2024/0360

46 Folly Way, Monk Bretton, Barnsley, S71 2SP

Removal of existing detached garage and erection of two storey side extension.

PRO PLANS & ELEVATIONS

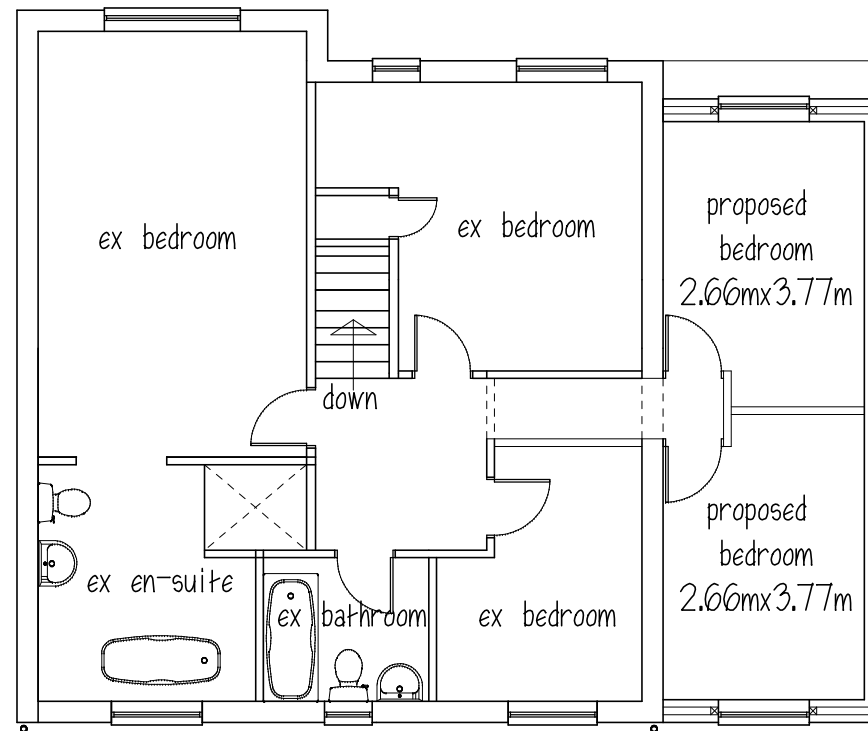
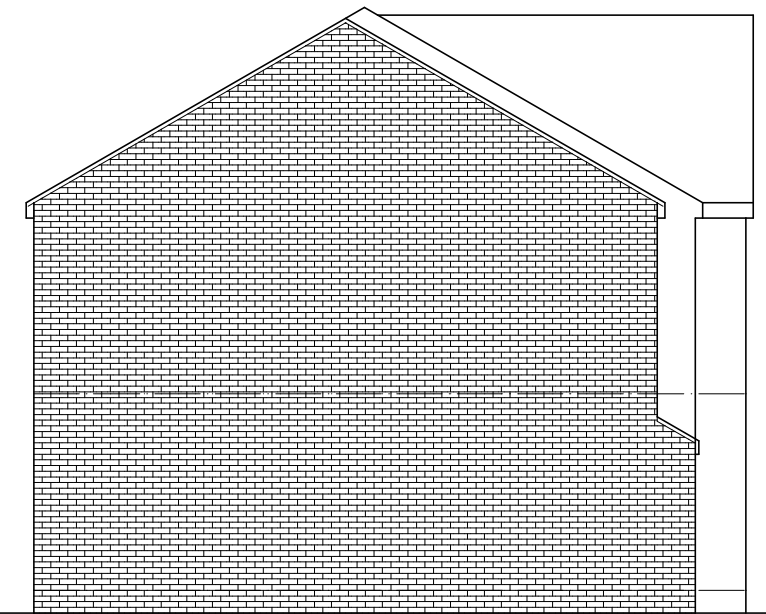
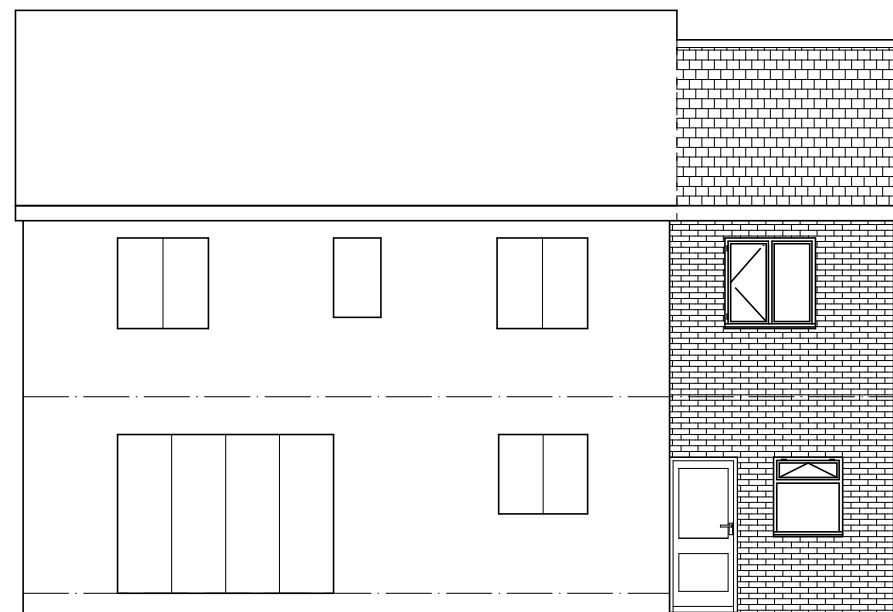
The proposed extension would project from the north-west side elevation of the application property by approximately 3 metres and would have a depth of approximately 8.8 metres. The extension would adopt a pitched roof with an approximate eaves and ridge height of 5.4 metres and 7.8 metres respectively. The extension would be constructed of materials that would closely match those used in the external construction of the existing building.

The proposed extension would be erected to the south-east of adjacent 48 Folly Way. Generally, extensions located to the south, south-east and south-west of neighbouring properties are likely to have a greater impact regarding overshadowing. As such, it is acknowledged that some overshadowing could occur. However, any potential impact would be limited to the blank side gable elevation of the neighbouring property and no habitable room windows would be impacted.

New first-floor windows would be limited to the front and rear elevations of the proposed extension. The House Extensions and Other Domestic Alterations SPD states that 12 metres should be maintained to a blank gable wall and 10 metres should normally be provided between rear-facing windows on the first floor (and above) and the rear boundary, and that windows to habitable rooms on an extended property should not be less than 21 metres from any other properties with habitable room windows. In this instance, a sufficient distance would be maintained to the rear north-east boundary and approximately 11.6 metres would be maintained to the blank gable elevation of 1 Beacon View. Whilst this would be less than the 12 metres stated in the House Extensions and Other Domestic Alterations SPD, the difference would be negligible. The distance maintained between the

front-facing first-floor habitable room window of the proposed extension and the habitable room windows of 27 Folly Way would be less than 21 metres, contrary to the House Extensions and Other Domestic Alterations SPD. However, the existing separation distance between the properties is less than 21 metres and the proposal would not lessen the existing distance and would therefore unlikely result in a significant loss of privacy.

During the application process, concerns were raised regarding overlooking and reduced privacy due to a rear-facing window and the proximity of the proposed extension to the north-east boundary and 48 Folly Way. The first-floor rear-facing window of the proposed extension would face into the application site and not directly towards the rear curtilage of the neighbouring property. Moreover, the extension would not project beyond the rear elevation of the application property and the new window would be aligned with existing first-floor windows. As such, any potential impact is unlikely to be significantly more impactful than any existing level of impact which could be experienced. Additionally, a single storey extension with the same footprint to that proposed could be erected as permitted development therefore not requiring planning permission and could draw similar concerns.

The proposed extension would follow the footprint of the existing dwellinghouse and would not obstruct any windows to the application and neighbouring properties. Moreover, no windows would be located on the north-west side elevation of the extension. As such, the proposal is unlikely contribute to reduced levels of outlook.

The proposed extension would be visible from the public realm of Folly Way and would form a prominent feature within the street scene. The House Extensions and Other Domestic Alterations SPD states that the design of a side extension should reflect the design of the existing property in terms of roof style, pitch, materials and detailing, and should not have an excessive sideways projection of more than two thirds the width of the original property. Moreover, all two-storey side extensions should have a pitched roof following the form of the existing roof, and to prevent a terracing affect and to avoid detrimental changes to the character of the street scene, it will be desirable to provide a setback of at least 0.5 metres from the main front wall of the property. In addition, and where practicable, a side extension should also be set in by one metre from the side boundary with an adjacent property.

In this instance, the proposed extension would be constructed of materials that would closely match those used in the external construction of the existing building and would adopt a pitched roof that would follow the form of and be set below the ridge of the existing roof. The proposed extension would not adopt an excessive sideways projection of more than two thirds the width of the original property, and a set back from the main front wall of the application property of approximately 0.5 metres would be provided at first floor level, in accordance with the House Extensions and Other Domestic Alterations SPD. It is acknowledged that the proposed extension would not be set in by one metre from the north-west side boundary, contrary to the House Extensions and Other Domestic Alterations SPD. However, it is not considered practicable to provide this as it would significantly impact the practical usability of the extension. Moreover, as the extension would be set below the ridge of the existing roof of the application property and 48 Folly Way and set back from the main front wall of the application property at first floor level, it is considered that the proposal would appear subservient, and a detrimental terracing affect would be avoided.

The proposal would result in the loss of some existing off-street parking to the side of the application property and the loss of an existing detached garage to the rear. However, the proposed extension would incorporate an integral garage at ground level. The garage would not be sufficiently sized to be counted as a parking space as outlined in the South Yorkshire Residential Design Guide and the House Extensions and Other Domestic Alterations SPD. However, the internal space that would be created would be larger than the size of a standard off-street parking space (2.5 metres by 5 metres) and therefore it is accepted that the garage could be used for parking cars. Moreover, the proposal shows that the paving to the front of the application property could accommodate a minimum of two off-street parking spaces, in accordance with the parking SPD. If an existing dropped kerb needs to be extended or a new dropped kerb needs to be installed to facilitate off-street parking, the applicant will need to apply for a dropped kerb license. As such, a standard informative will be attached to any forthcoming decision.
